Application for Planning Permission

Development: Replacement residential dwelling. This application may affect a Public Right of Way.
Location: 3 The Hard Elmer Middleton-On-Sea PO22 6JS

PROPOSED FIRST FLOOR PLAN 1:50

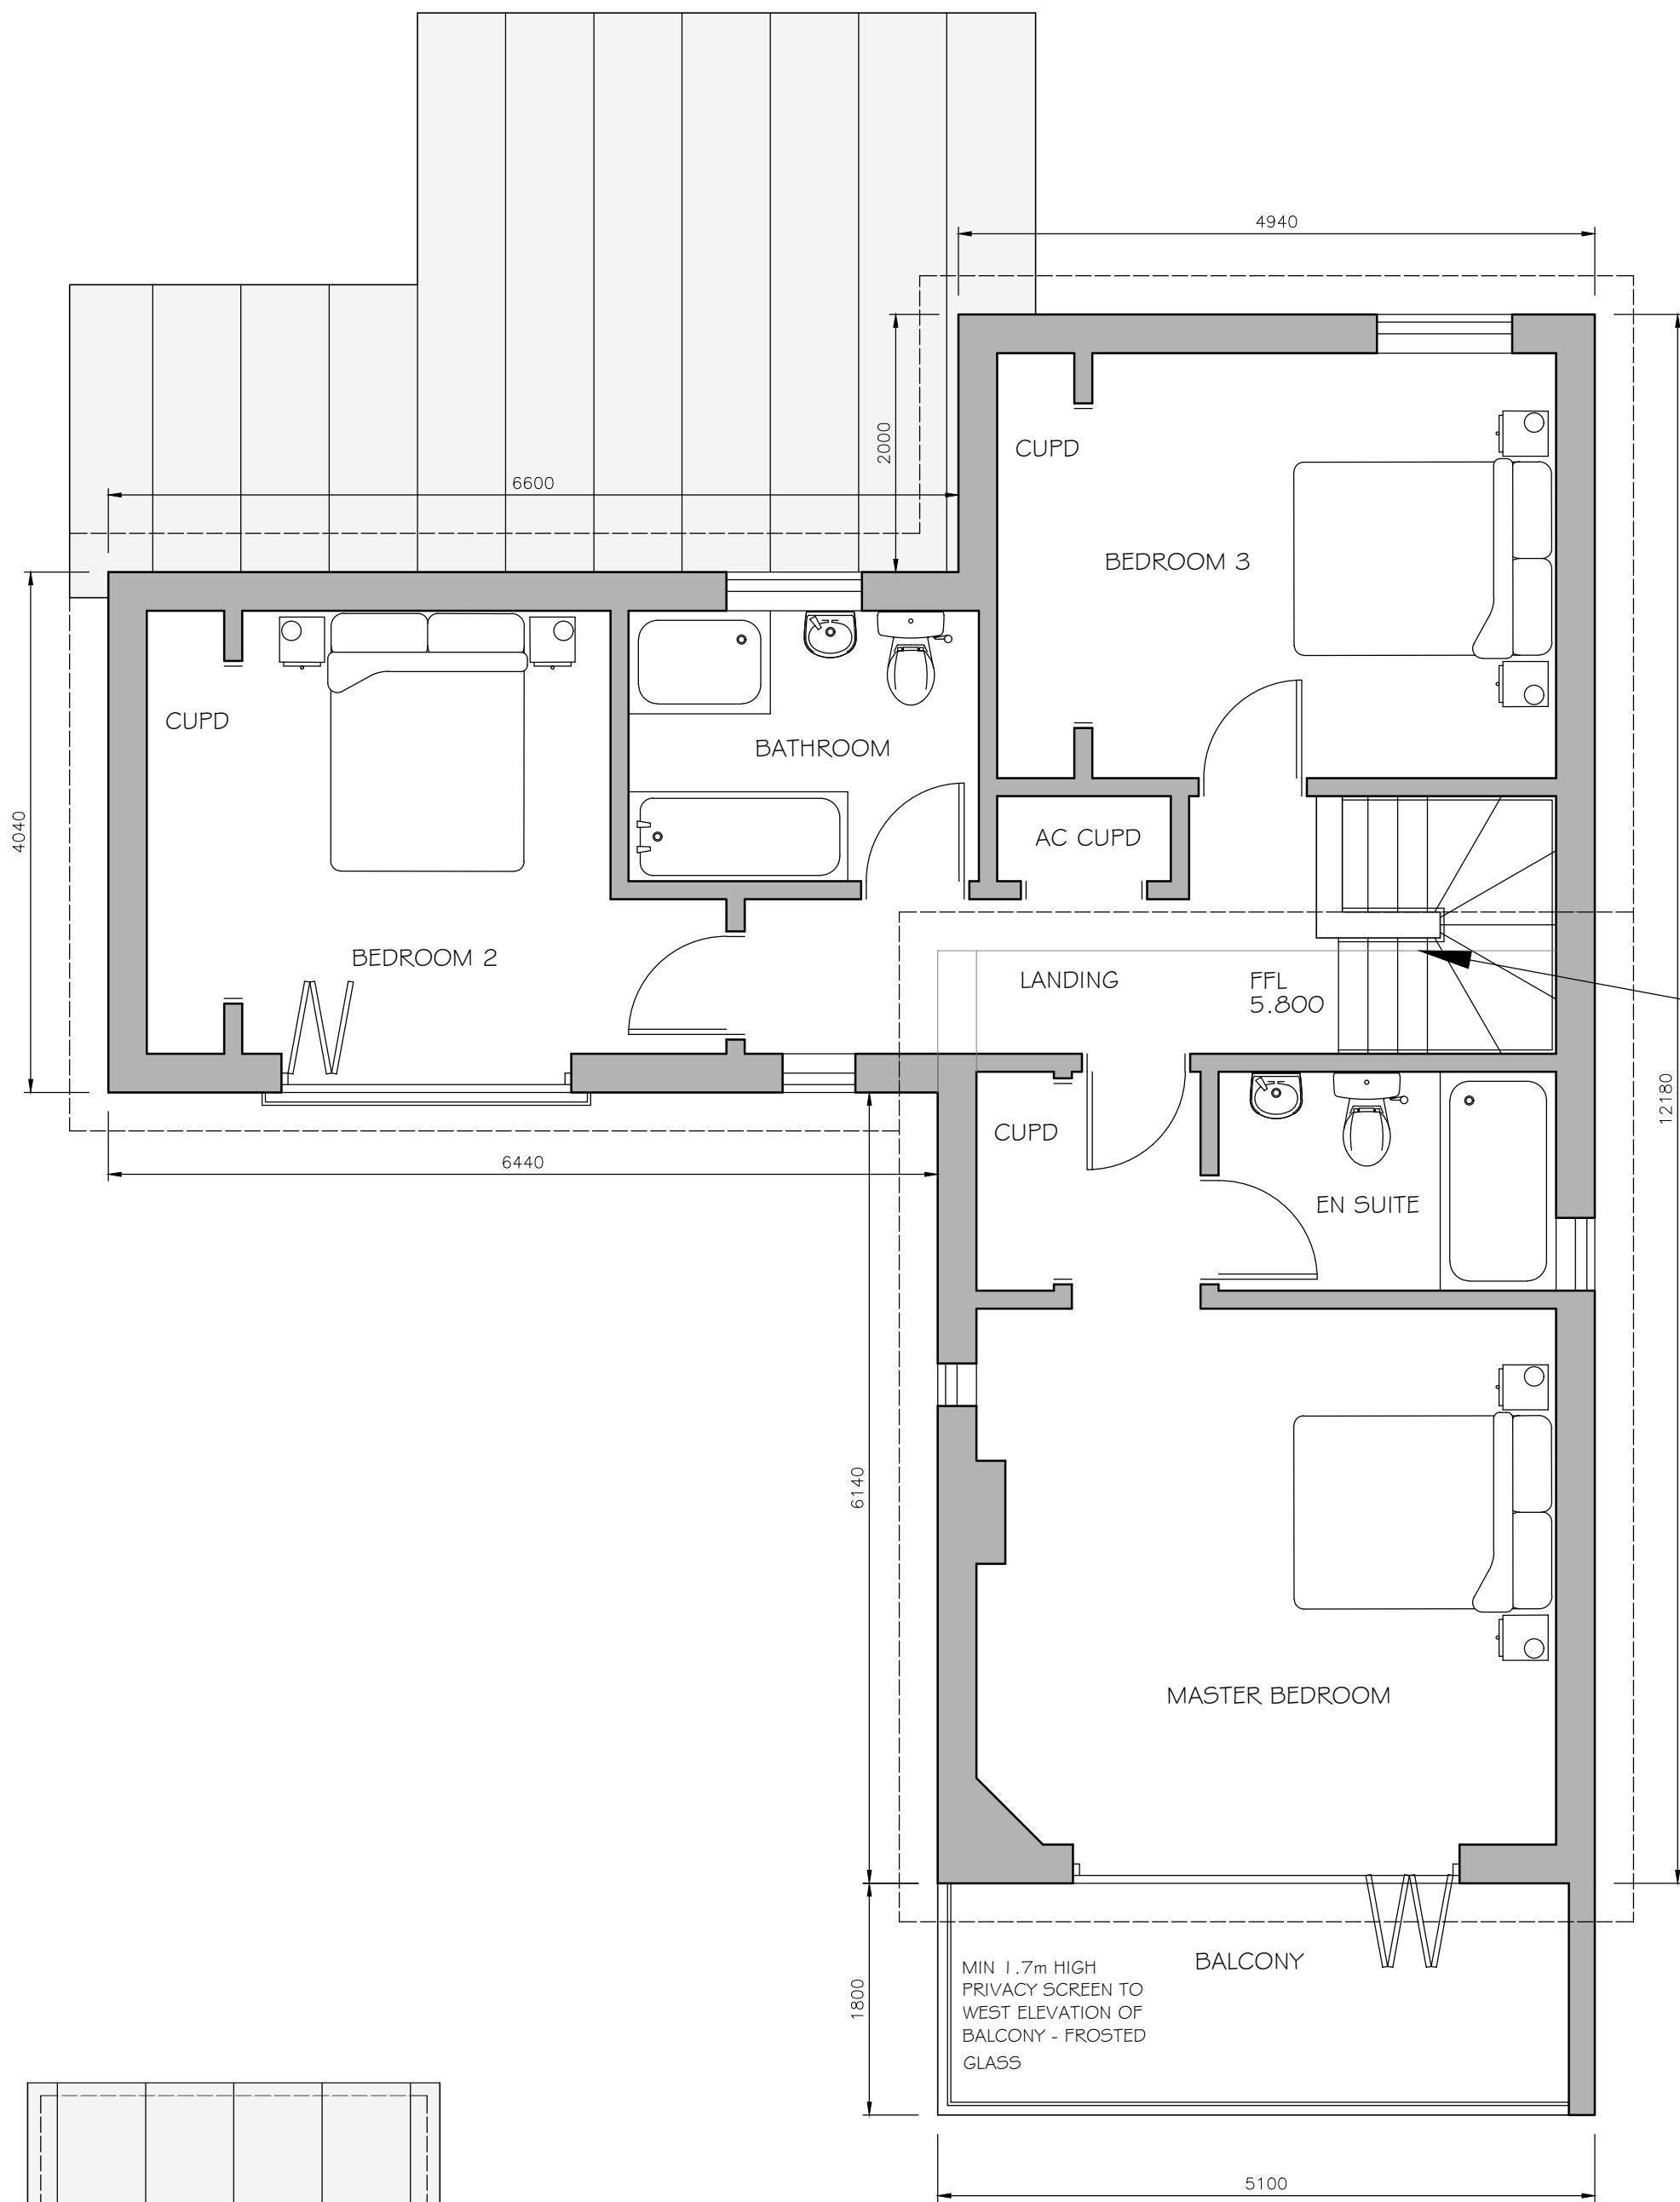
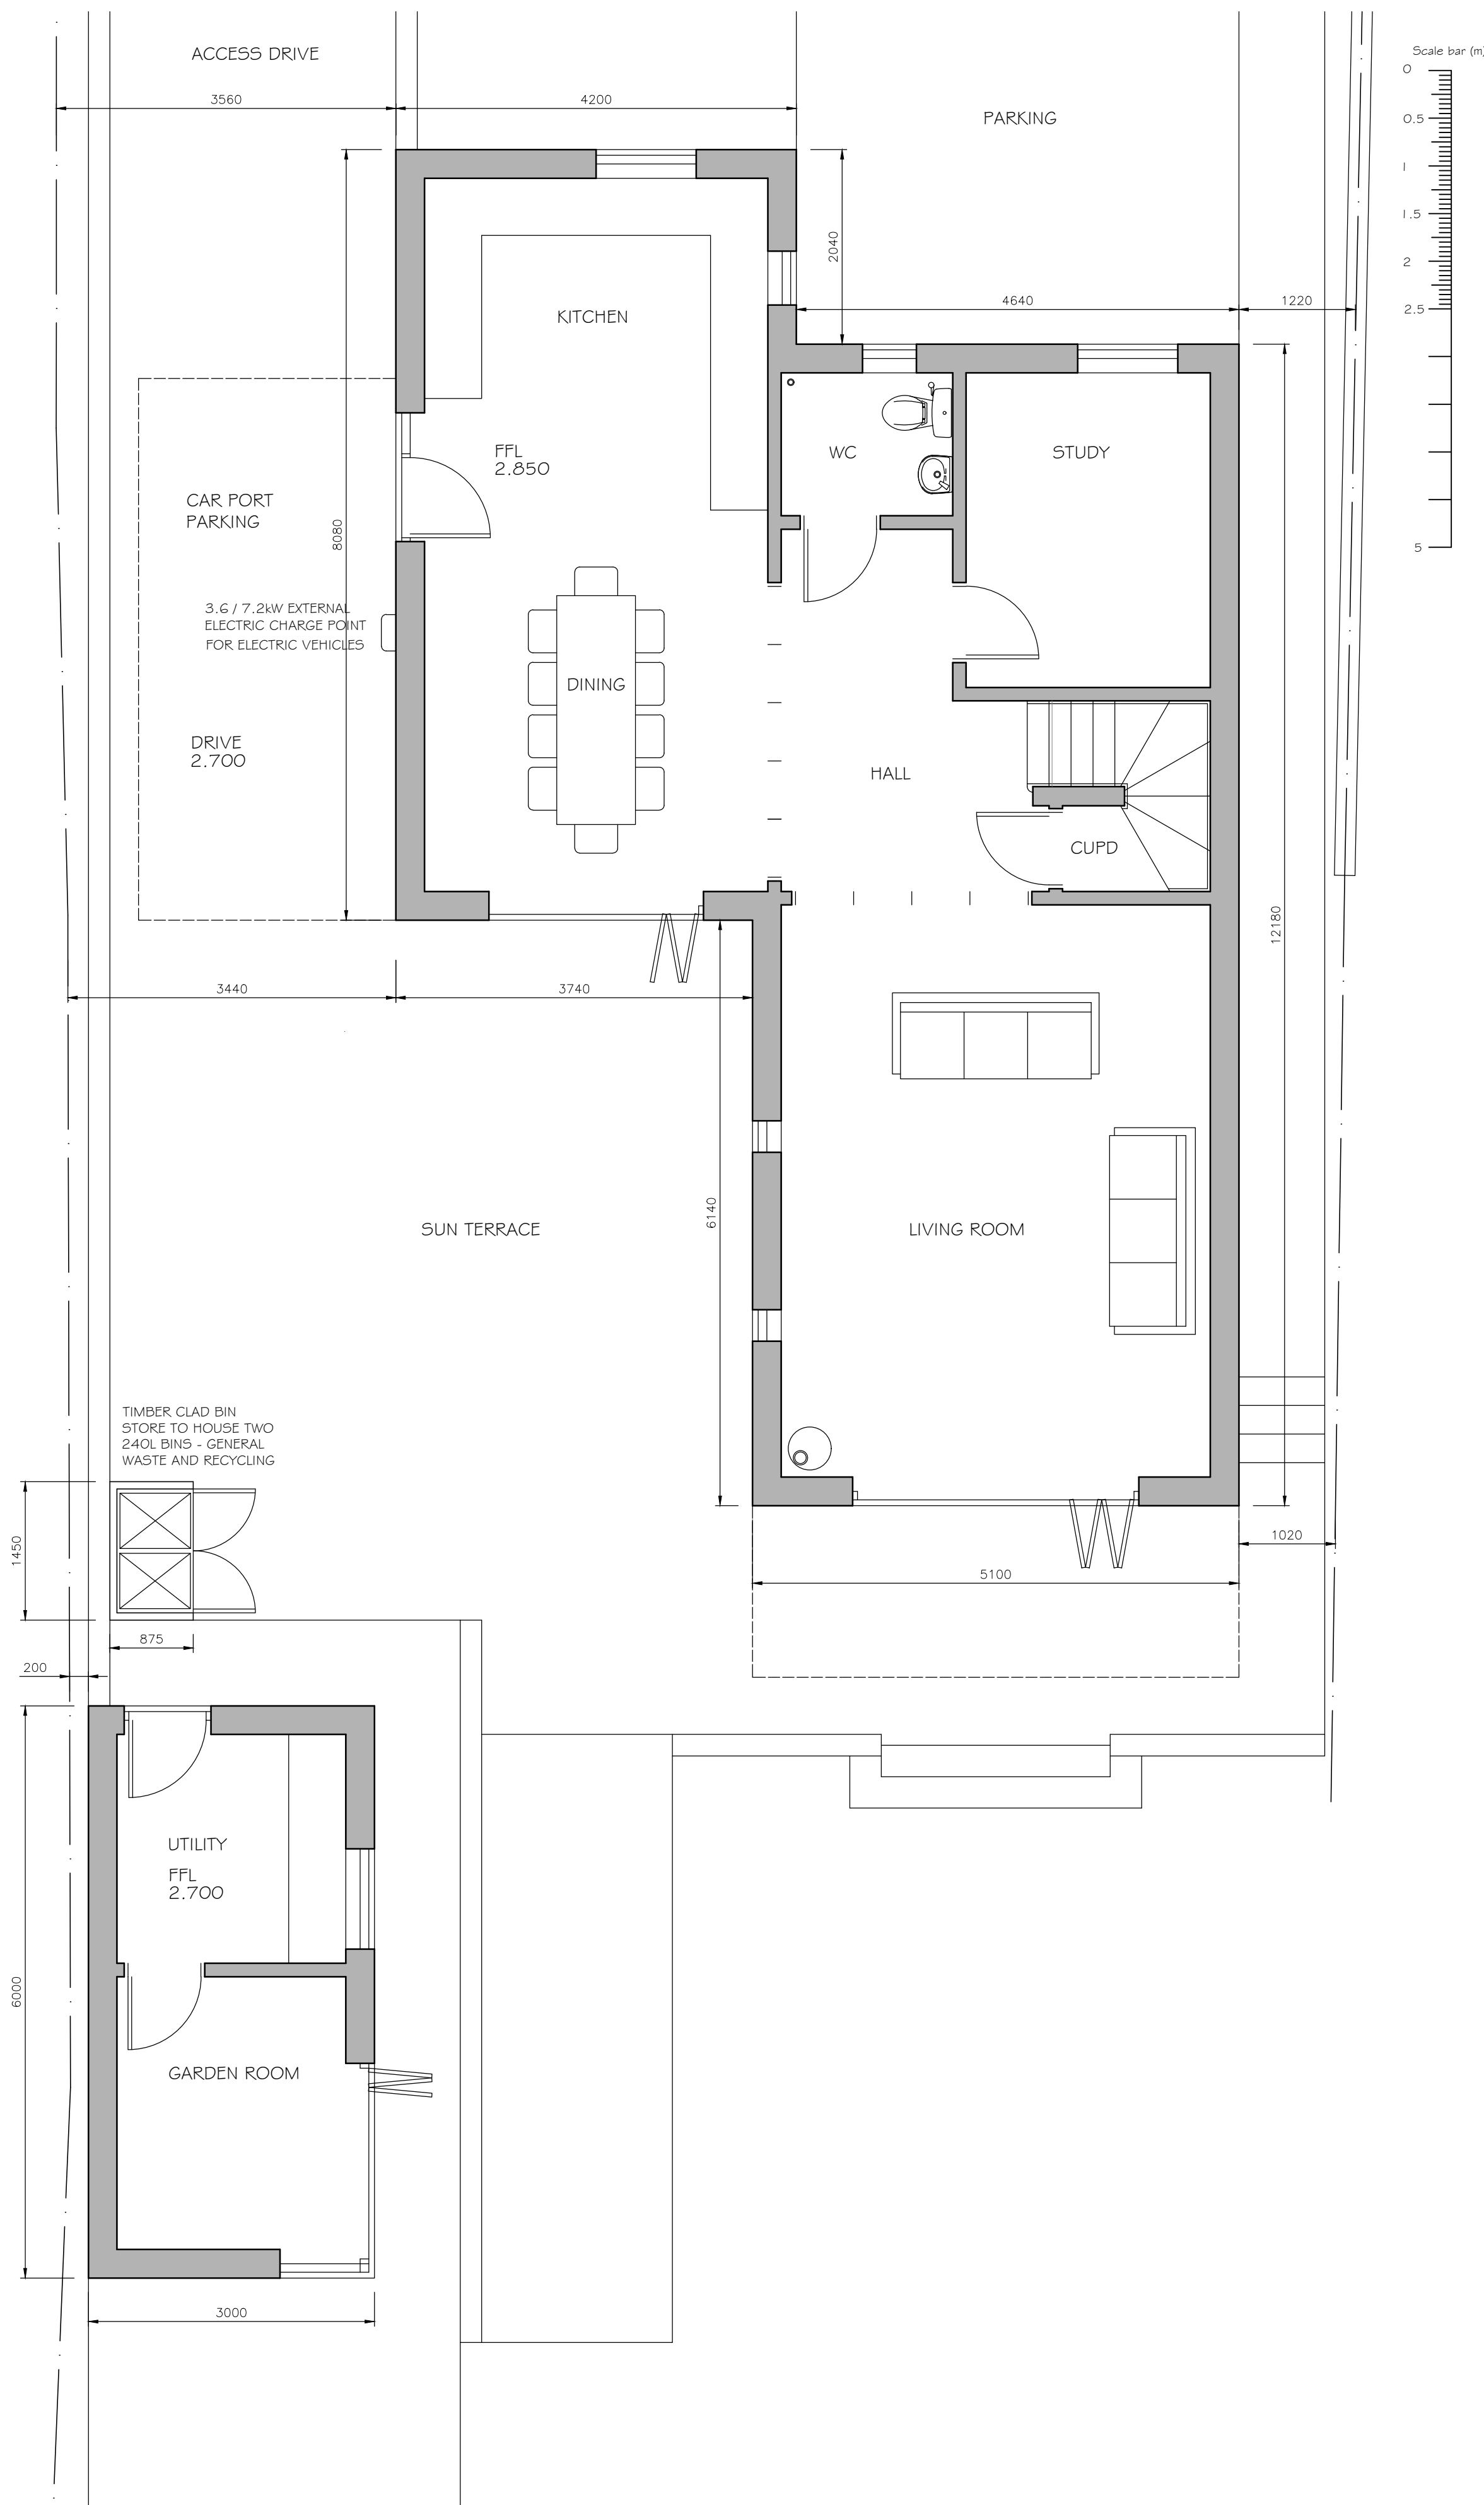
The South elevation 1st floor windows measure: 2.2m, 0.3m and 2.9m, but on the Proposed 1st floor plan measure 2.2m, 0.5m and 2.9m. Please check the measurement of the middle window, amend accordingly and re submit.
